Application No: EP/2/21/HH
Site Address: 27A Sea Lane East Preston BN16 1NH
Description of works: Erection of front extension to create first floor balcony, erection of rear balcony, demolition of existing conservatory with changes to external materials and wall finishes.

This council's Planning & Licensing Committee considered this Application at its meeting on Monday, 22nd February. The applicants were invited and attended and addressed the meeting.

Elevations (1:100)

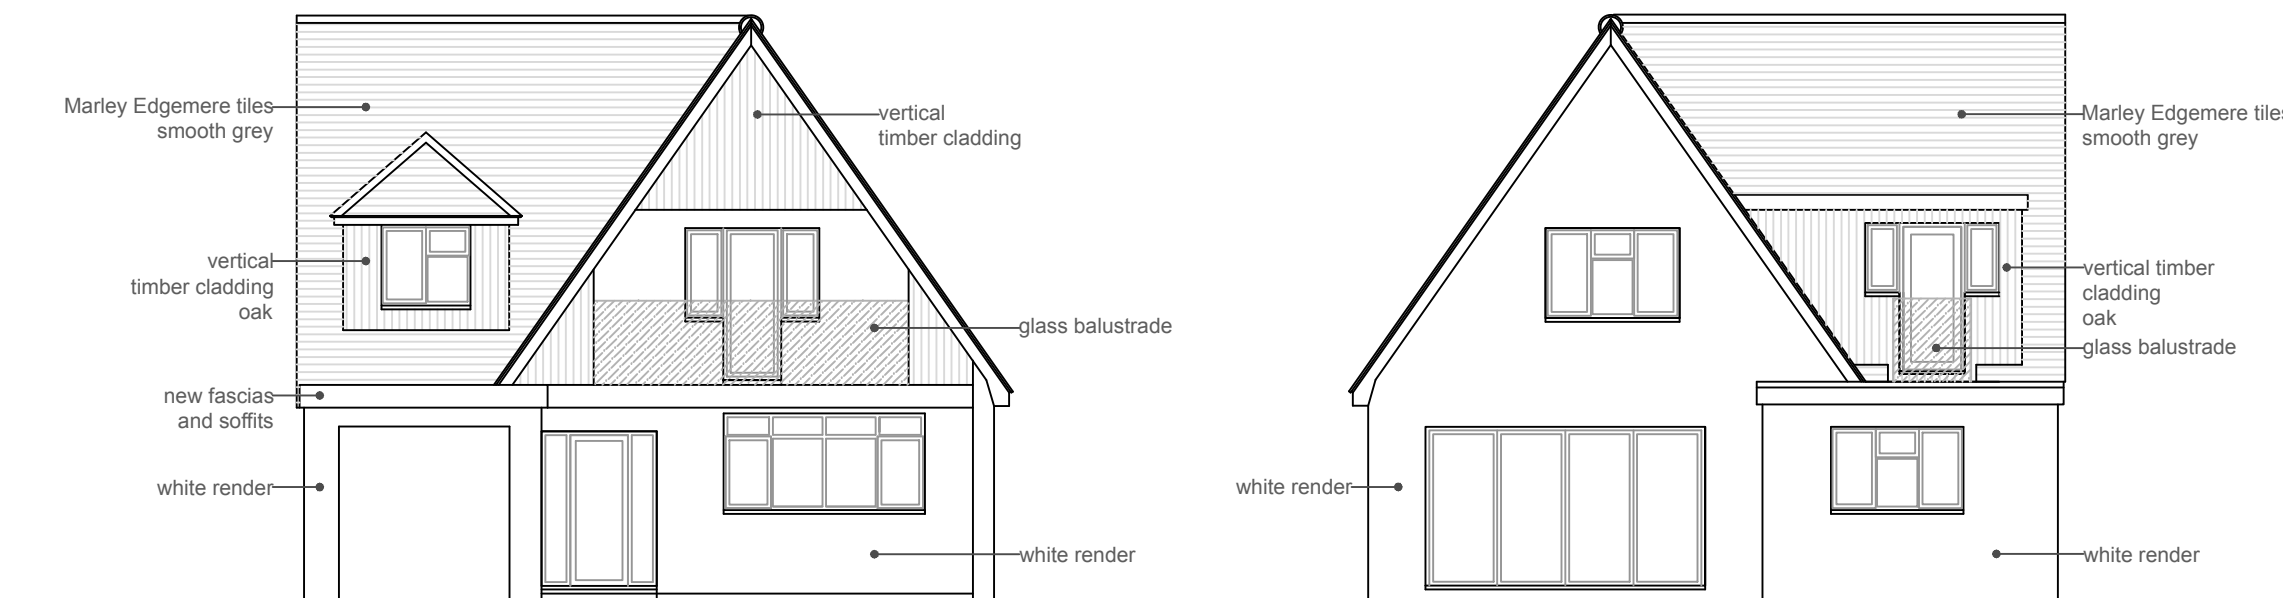
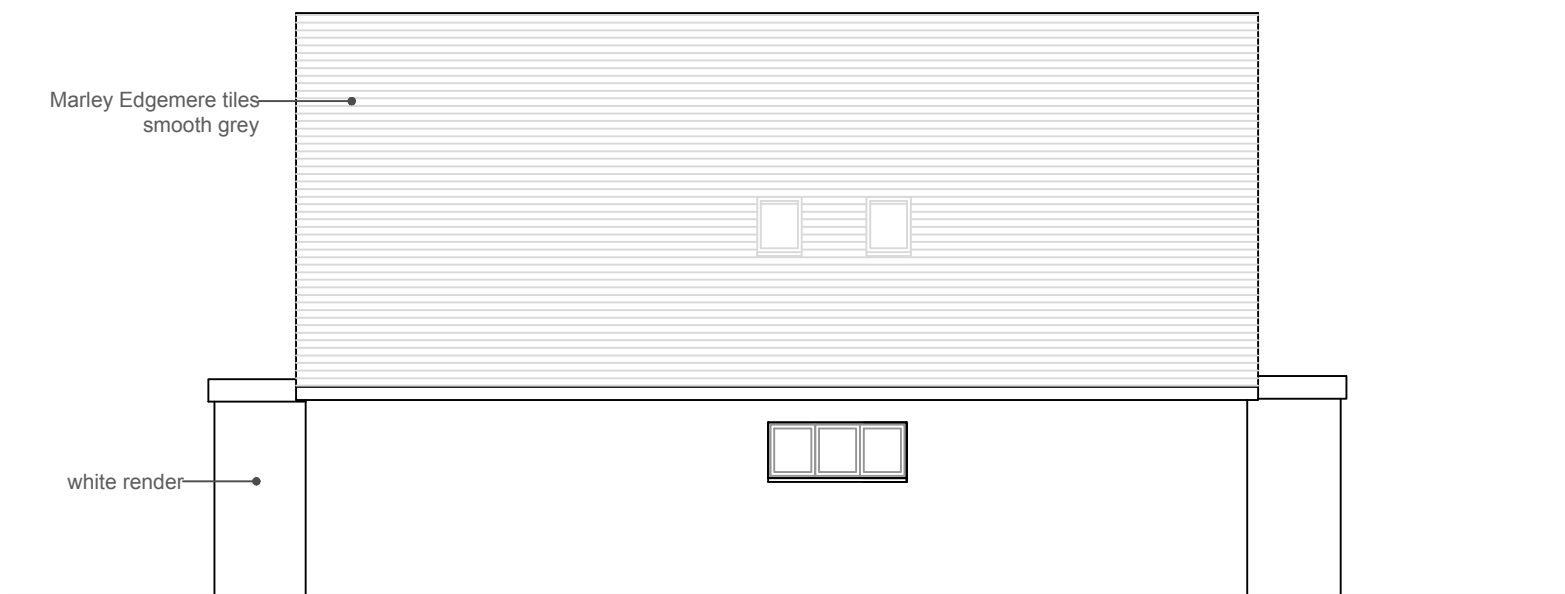
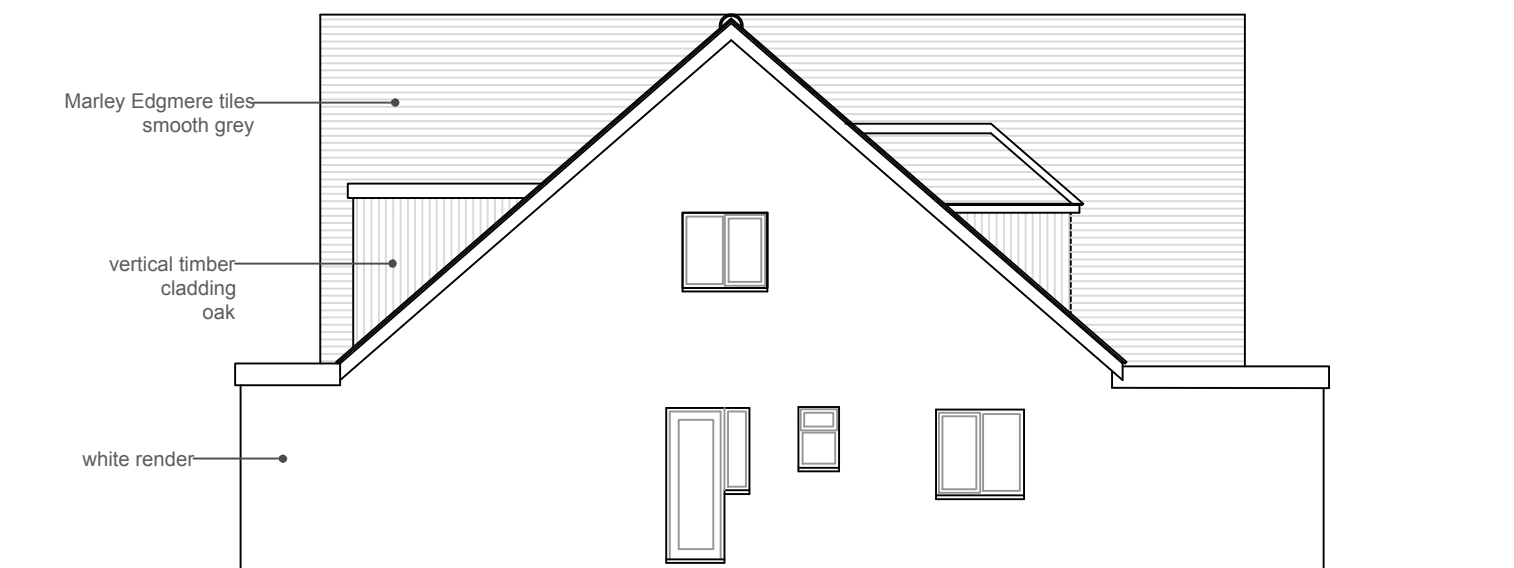
The proposed rear balcony could lead to unacceptable overlooking of neighbours in Sea Lane, Normandy Drive and Oakley Gardens, some of whom have already contacted both councils with their concerns. The council felt this proposal conflicted with Arun Local Plan Policy D DM1 as it does not avoid significant loss of privacy. Both proposed balconies could be in conflict with Policy D DM4 too as they may be said to have an adverse overbearing effect on neighbouring properties.

The front balcony and the proposed materials for the redevelopment would not be in keeping with older properties in Sea Lane, particularly no 27 to the immediate north of this property. The slate effect tiles would be out of keeping with pretty much all other properties in Sea Lane, all of which have retained their clay tiles, even recently-built properties such as the block of flats at 17 Sea Lane. This latter property is also the only property in Sea Lane to have a front balcony. This proposal is, therefore, contrary to Paragraph 4.12 within Policy 1 of the East Preston Neighbourhood Plan as the chosen materials would not harmonise in both colour and texture with the materials used in adjoining buildings.
